Your Ref: OWPC20111
Our Ref: R/190/18/PL 31-07-2018
Please ask for:
Mrs A Gardner

Demolition of 1 No. existing house & grounds & erection of 2 No. new detached dwellings. This application may affect the character & appearance of the Station Road, East Preston Conservation Area.

St Marys Close Hurst Road Rustington

Thank you for your internet representation made on 7th October 2018 which has been recorded as '**an objection**' with the comments as follows:

Drawing Title:
ADDITIONAL DWELLING
PLOTS 1 & 2
ELEVATIONS

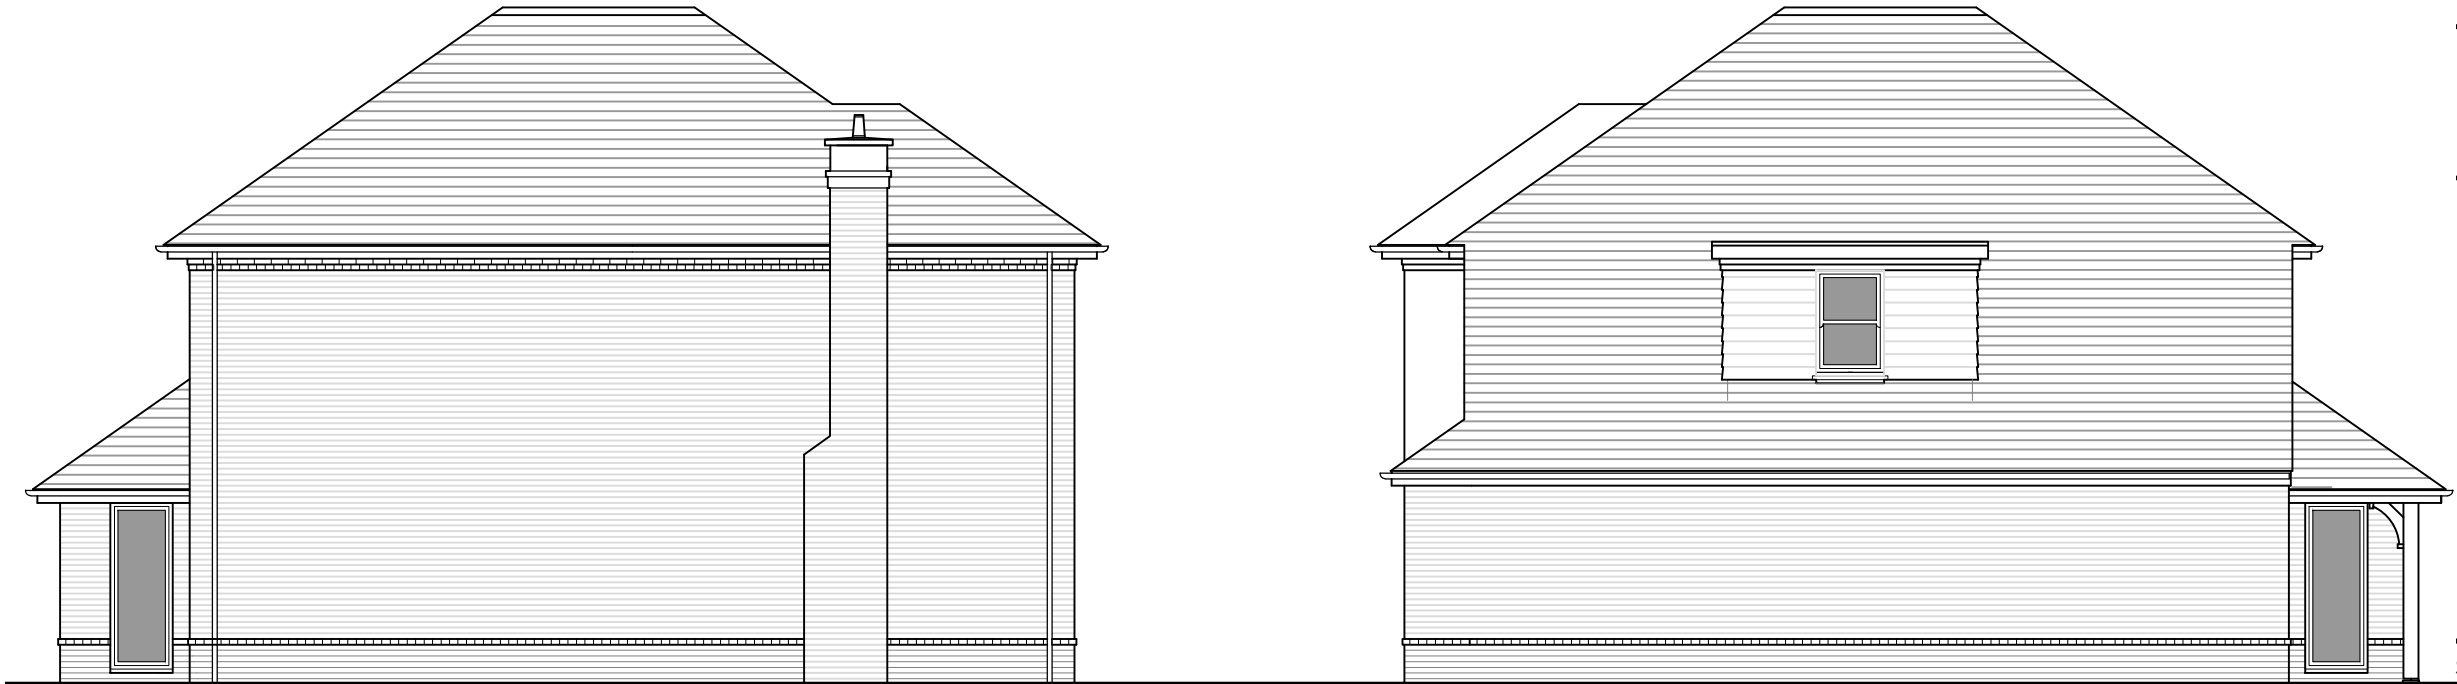
It will spoil the look of the road if both of the houses look the same.
